From: Kevin Patton <Kevin.Patton@PulteGroup.com>
Sent: Wednesday, December 18, 2019 9:13 AM
To: Cherne, Curtis; Yolanda Padilla Moyer; Roeder, James A.; Biazar, Shahab
Cc: Adeeb, Muhanned W
Subject: RE: Del Webb 3A

I have reviewed the Design Revision sheets 6R and 15 (should be 15R) as well as the drainage report stamp date 6-14-18 and the Amendment 1 labeled January 23, 2019, but stamped 1-23-18 (yes, 18, think off by one year) and provide the following comments:

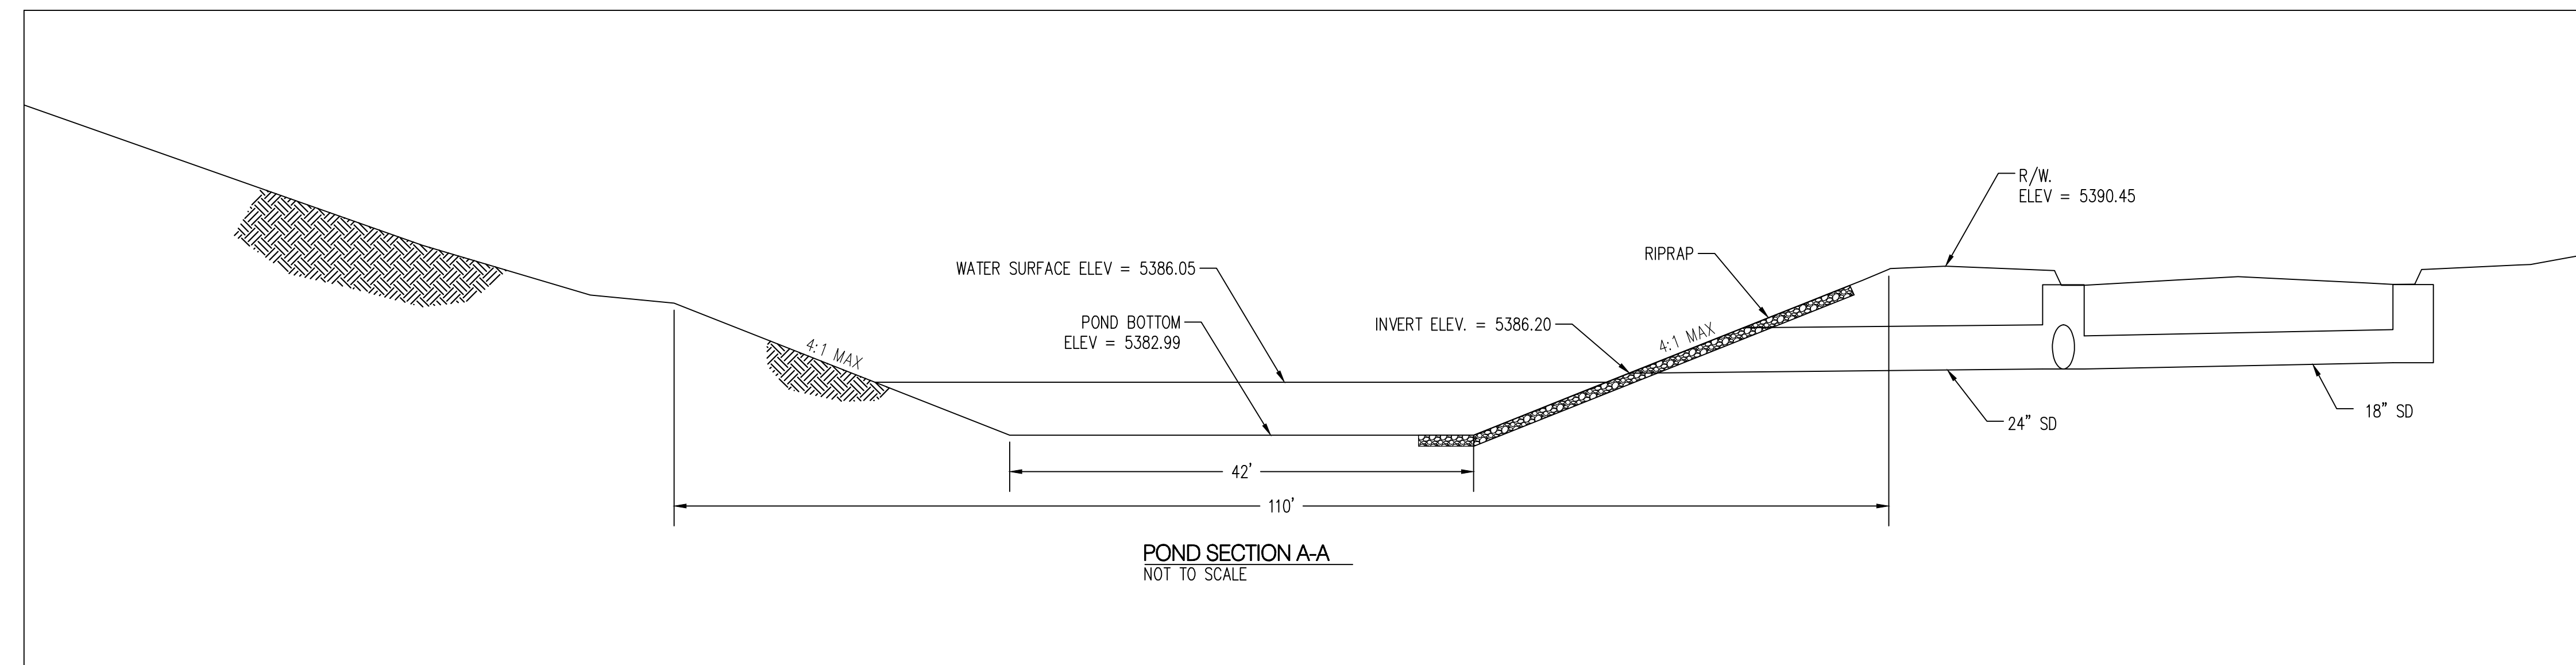
1. It appears the water surface elevation on Sheet 15R is incorrect. The drainage report stamp date 6-14-18 states a Q in of 52.2 cfs and a Q out of 44.2 cfs with a required detention volume of 7551 cu ft. Therefore, the water surface elevation would be higher than 86.05 as this elevation corresponds to 6963 cu ft and it seems there is 7551 cu ft. **Not sure where the table came from in the detention pond appendix, it is an error on BHIs part. This is not a detention pond but strictly a first flush pond. The total Q100 getting to pond is 52.2. (Basin 3-j, 3-k, 3-m and 3-l, 4-b, 4-j, 4-h, and offsite3 and inlet 11 &12). Qout of the pipe is 44.2cfs. The first flush calculation in the report has a required volume of 6863.50 cf which translated to a WSEL of 5386.05. The volume to allow the 44.2 cfs out of the pond is 7551.1CF which is an elevation of 5386.20. The top of pond/ROW is 5389.02.**

3. Comments on Sheet 15 (15R)

- a. Rename sheet to 15R. **See enclosed drawing for the stamp and revision**
- b. Seal the sheet. **See enclosed drawing for the stamp and revision**
- c. Revise water surface elevation and required volume based on comment #1. The actual volume looks considerably larger than the 6963.12. **See response to comment #1**

- d. It would be better to use the adjacent grade elevation of 89.05 on the pad directly north of the pond rather than the R/W ELEV of 00.45 as the road has a longitudinal slope..

- e. Pond section A-A shows riprap on the slope adjacent to the pond. Show the riprap in the plan view. In addition, specify aggregate size and thickness **Build note on Sheet 6R**

- f. Should the plan have the standard "NOTES" area similar to Sheet 6R? **Sheet shown to show the pond grading in relationship to the pond. All build notes are on Sheet 6R**

- g. Show Q,V, HGL on 30" pipe. **Shown on Sheet 6R**
- h. Remove the text "Temporary Pond". **See enclosed drawing for the stamp and revision**
